## DEVELOPMENT HEARING OFFICER

**PR-2022-0007712**

**SD-2024-00019 – FINAL PLAT**

**Project Name:** Tracts 1-A and 1-B, Block 2, Volcano Cliffs Subdivision

DOCH 2024014448
 SOUTH PLAT OF TRACT 1-A AND TRACT 1-B, BLOCK 2, VOLCANO CLIFFS SUBDIVISION, UNIT 26
 BERNALILLO COUNTY, NEW MEXICO

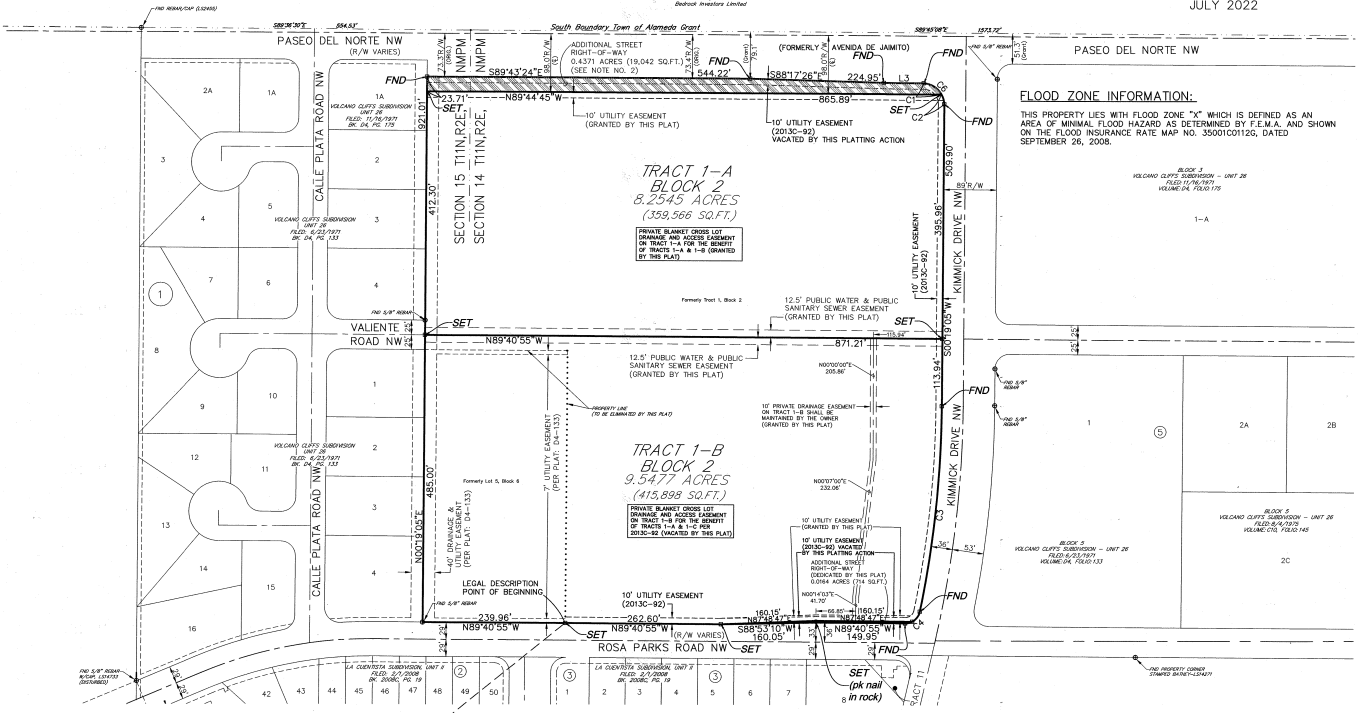
- The size of Tract 1-A on the Final Plat, 8.2545 acres, differs from the size of Tract 1-A on the Preliminary Plat and Preliminary Plat Extension, which was 8.2339 acres. Please confirm and explain the difference in size of Tract 1-A between the Final Plat and Preliminary Plat/Preliminary Plat Extension.

- The size of the right-of-way dedicated by the Plat along Paseo del Norte, 0.4371 acres, defers from the right-of-way dedicated by the Plat along Paseo del Norte on the Preliminary Plat and Preliminary Plat Extension, which was 0.4577 acres. Please confirm and explain the difference in size of the right-of-way dedicated by the Plat along Paseo del Norte between the Final Plat and Preliminary Plat/Preliminary Plat Extension.
- The review criteria for a final plat is below. Based on responses to the 2 preceding comments, these criteria may be fulfilled.

- The application number on the Plat must be corrected to SD-2024-00019.
- The DXF file must be approved by AGIS, and the approval email from AGIS must be submitted prior to final sign-off from Planning should the Plat be approved by the Development Hearing Officer.
- Per 6-6(L)(2)(d)(7) of the IDO, the date of the DHO approval shall be recorded on the Plat. Therefore, prior to final sign-off of the Plat, the date of the DHO approval must be added to the Plat.
- After DHO approval and final sign off, a recorded copy of the plat must be sent to Angela Gomez at [agomez@cabq.gov](mailto:agomez@cabq.gov) and to Jay Rodenbeck at [jrodenbeck@cabq.gov](mailto:jrodenbeck@cabq.gov).
- Per 6-6(K)(2)(I) of the IDO, the applicant shall record the Plat with the Bernalillo County Clerk within 3 months after the date of the final signature on the Plat, or the subdivision shall be voided.
